Traffic condition re Taco Bell, 1363 Washington Ave, Portland, ME

Jean Fraser, Planner
City of Portland
874 8728

Not Approved for Construction  
Drawing Title: **Layout & Materials**  
Drawing Number: \_\_\_\_\_

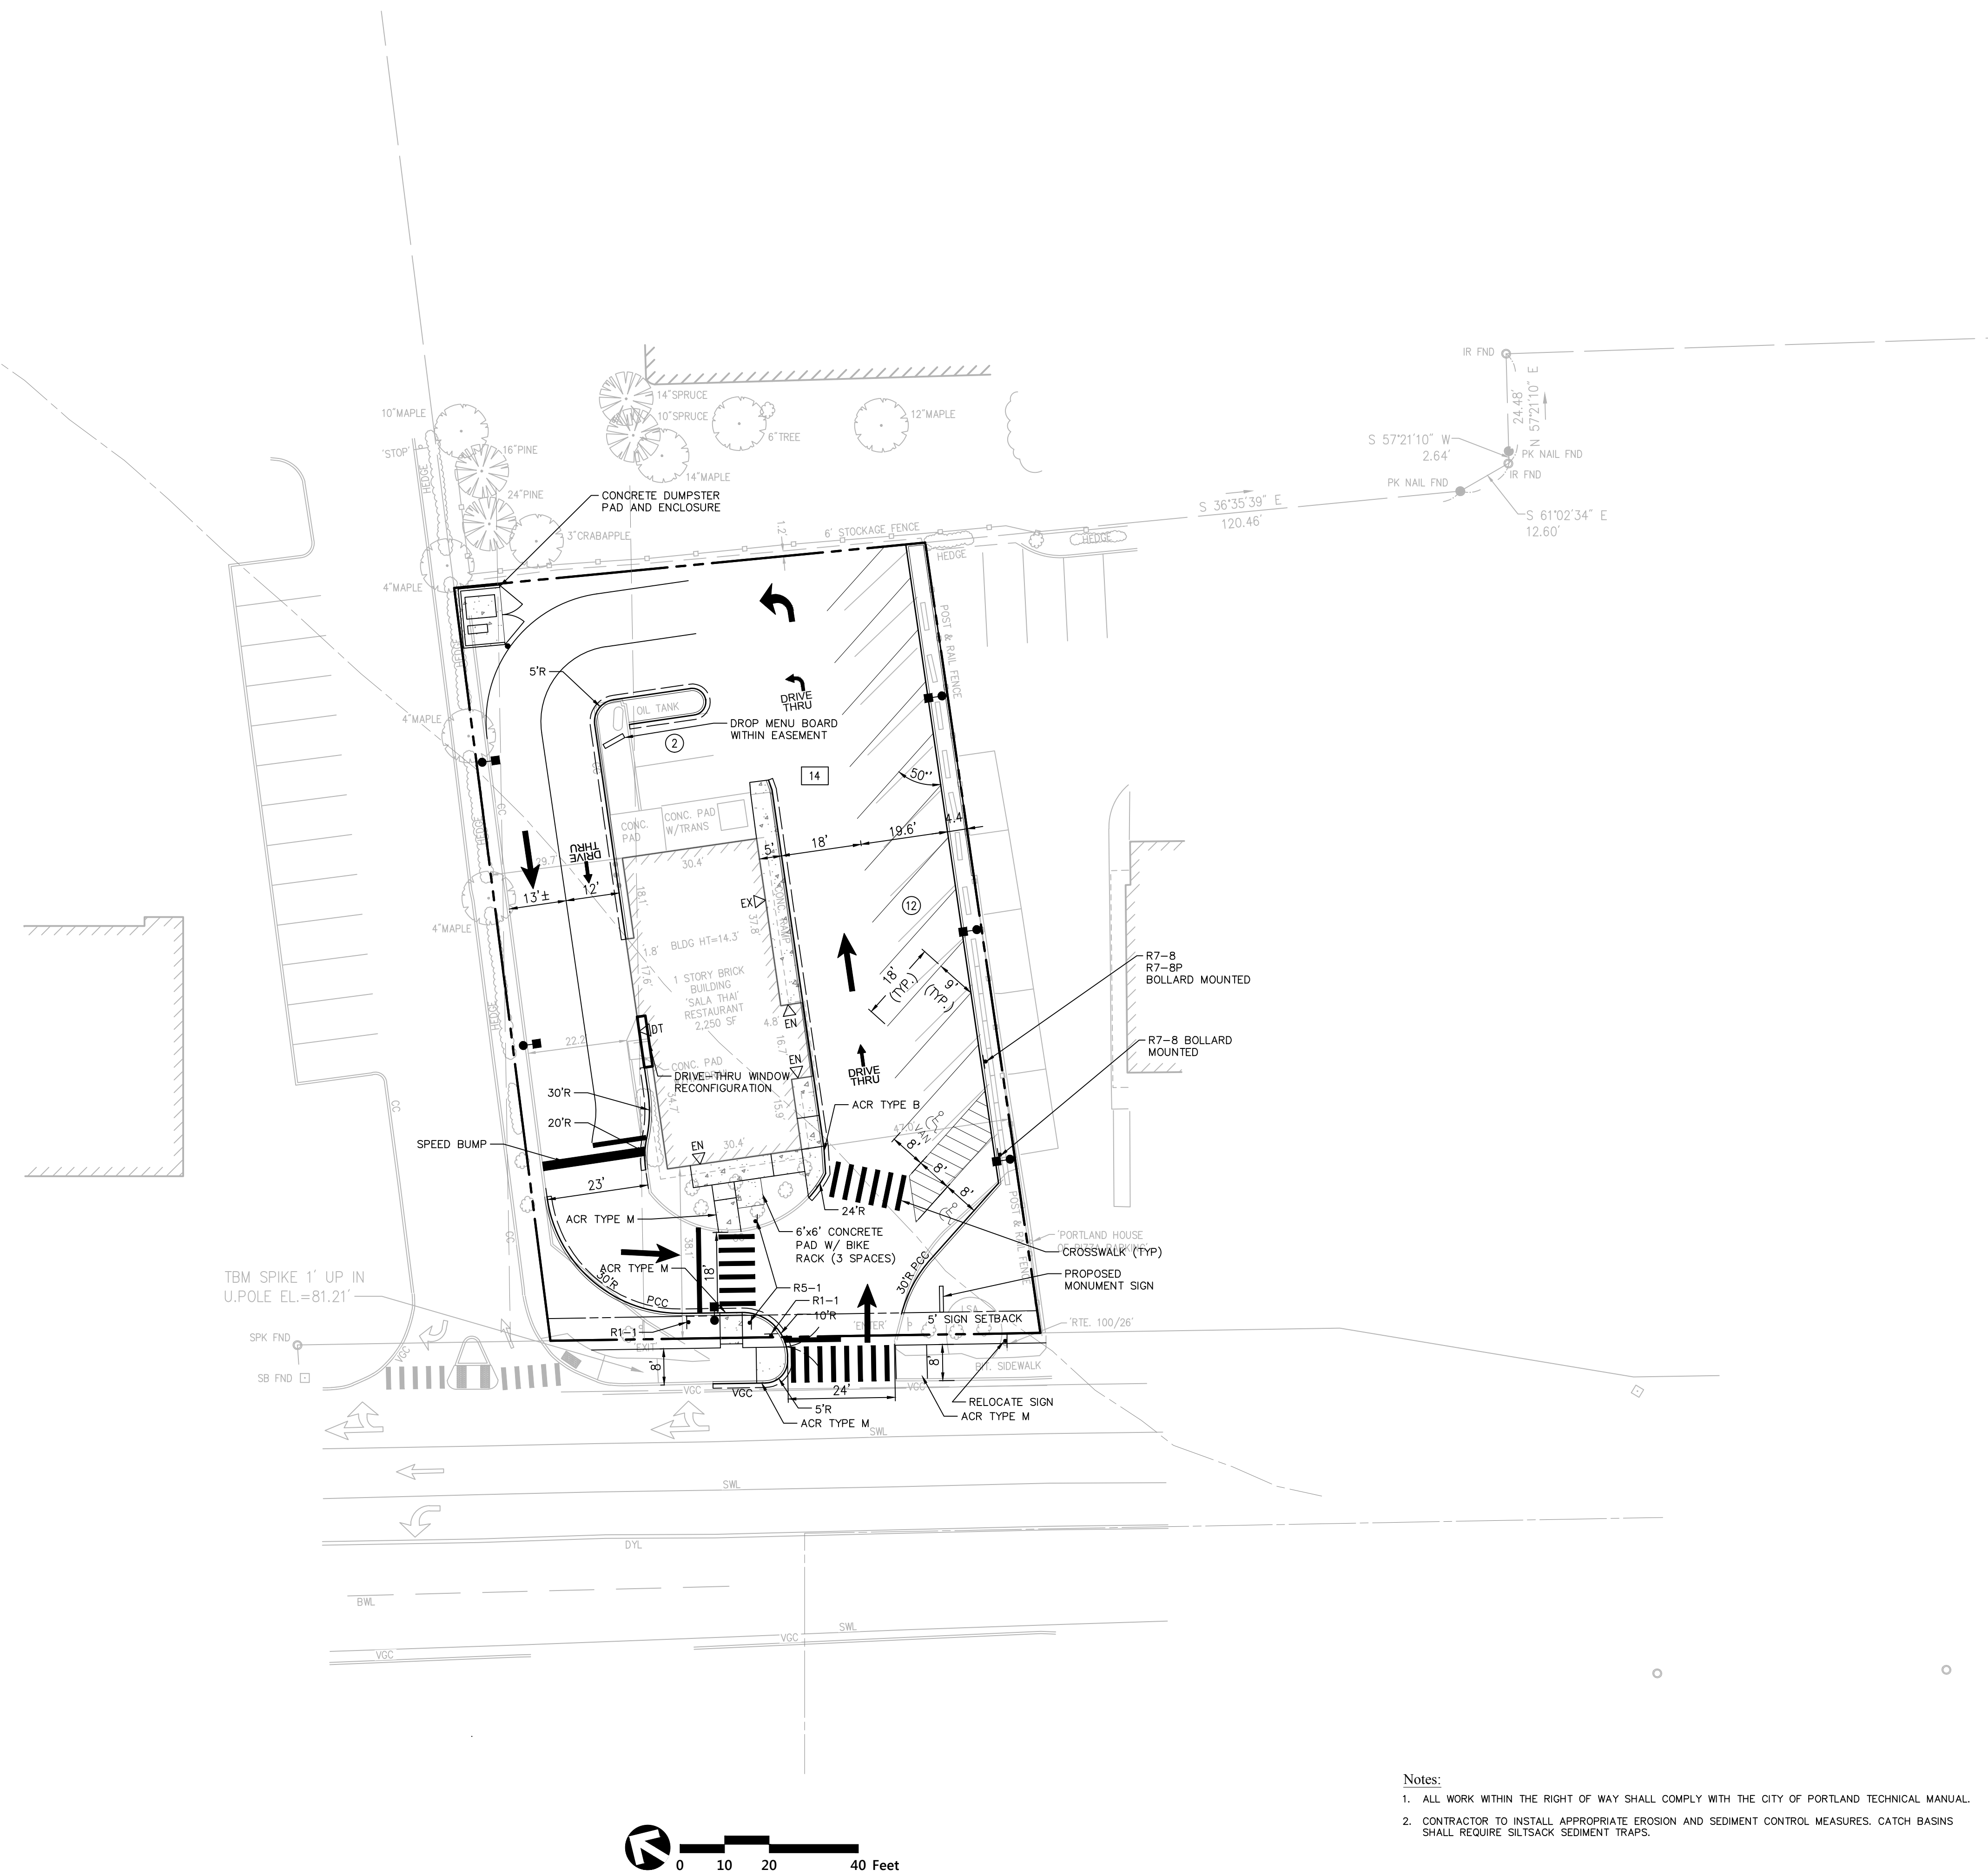
I have consulted with my colleagues and we are not supportive of the suggested revisions. The wording as originally presented already reflects a compromise given the high levels of traffic along that corridor, the nearby intersection that results in lane-changes, and the proposed intensification of traffic from the site because of the introduction of the Taco Bell drive through.

A key element of the original draft condition is that the City would preserve its discretion to determine, based on the monitoring information, what access modifications were necessary. Such modifications would be implemented and funded by the applicant (or current owner) and designed to ensure safety for both motorists and pedestrians including school children.

If the original draft condition (basis of your redline) is not considered acceptable to the applicant, then any approval will be subject to a condition requiring the restriction of the Washington Avenue access to right-in and right-out only. This restriction would not be required if the connection via the Rite Aid access drive were implemented by the applicant (in a form approved by the City), at the applicant's cost, prior to the Taco Bell being opened to the public.
